From: Michael Eastham
Sent: 12 April 2019 10:43
To: Planning.Responses
Subject: FW: Land at Walberton - WA/95/18/RES

Please upload the email below comprising the ADC Arboricultural Officer's consultation response on the emergency access onto Ocella for WA/95/18/RES.

It would appear that all construction can easily take place outside of the root protection area of the nearest tree (subject of an Order) T23, so I raise no objection in principle. This is an important category A tree. I would just like to re-iterate and as per my recommended conditions under the above planning reference:

Tree Survey & Constraints with Shading

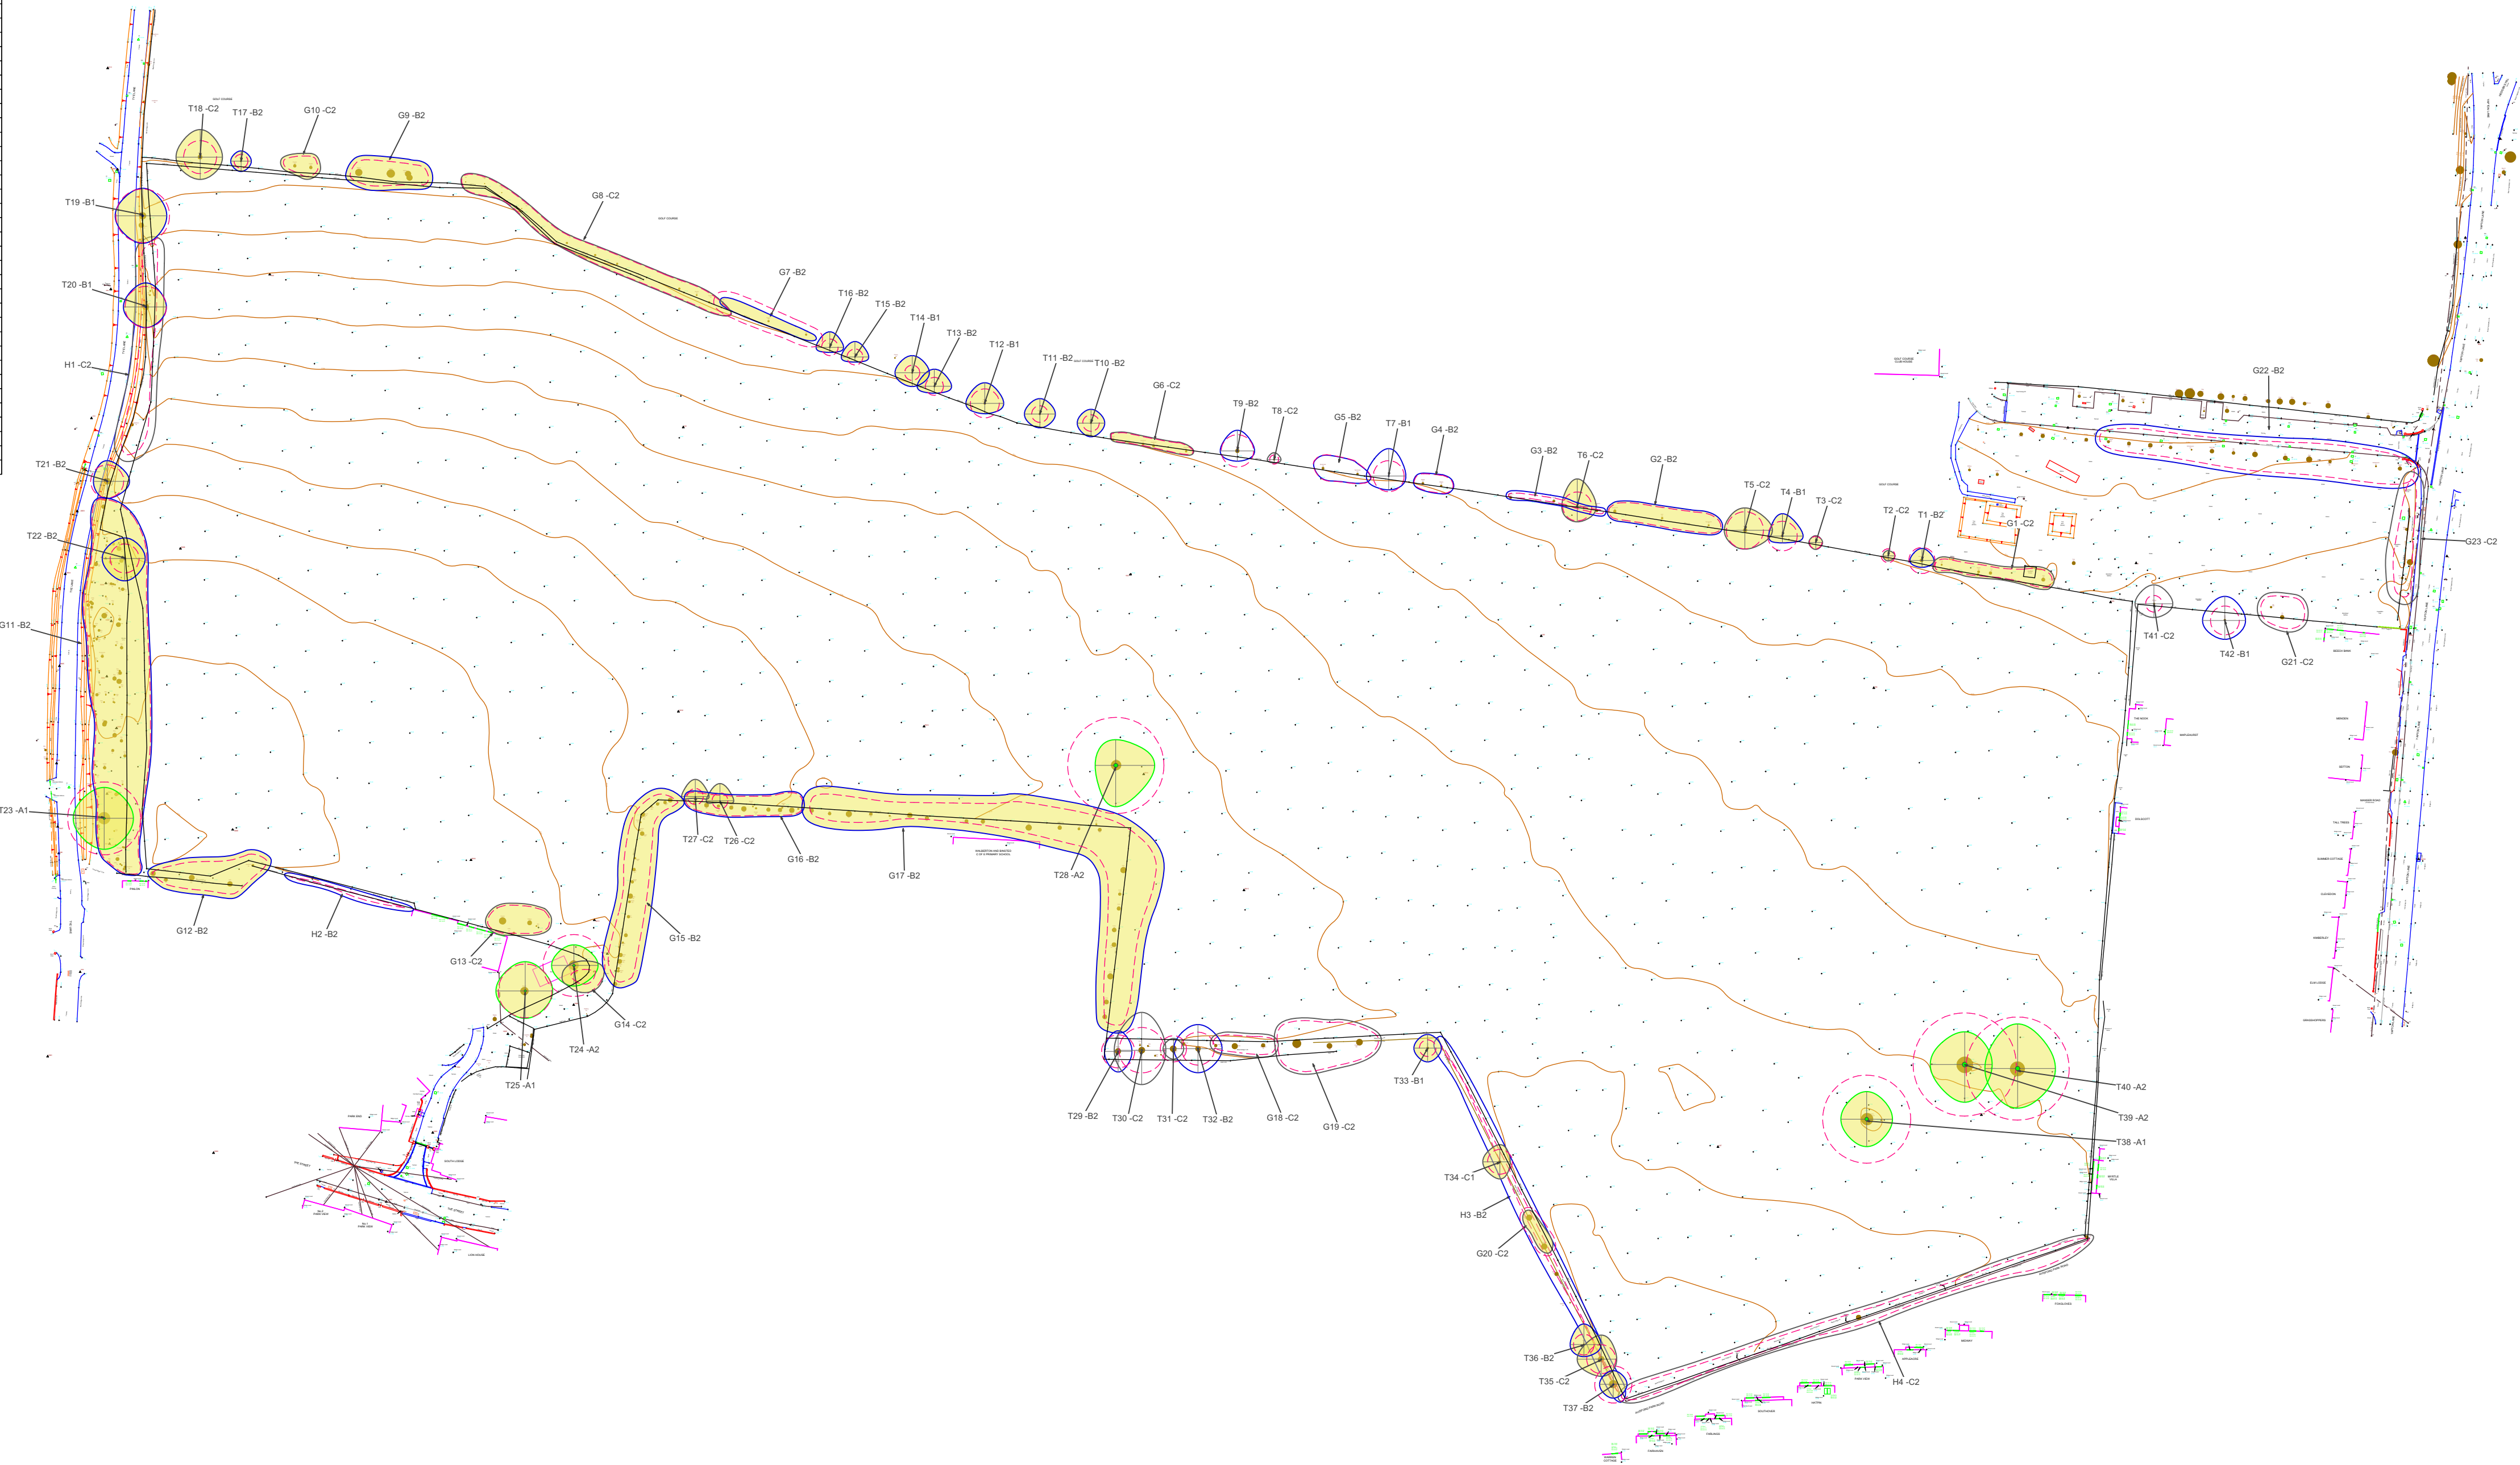
In respect of the latter, I would be prepared to waive the requirement for a separate AMS on this occasion, as no significant trees appear to be being sacrificed for this element of the scheme. That said, it appears to bisect a group of category B trees (within hedgerow) and so I would recommend their retained arboricultural consultant (Barton Hyett) be involved with all works to ensure losses/damage are kept to an absolute minimum and best practice is observed.
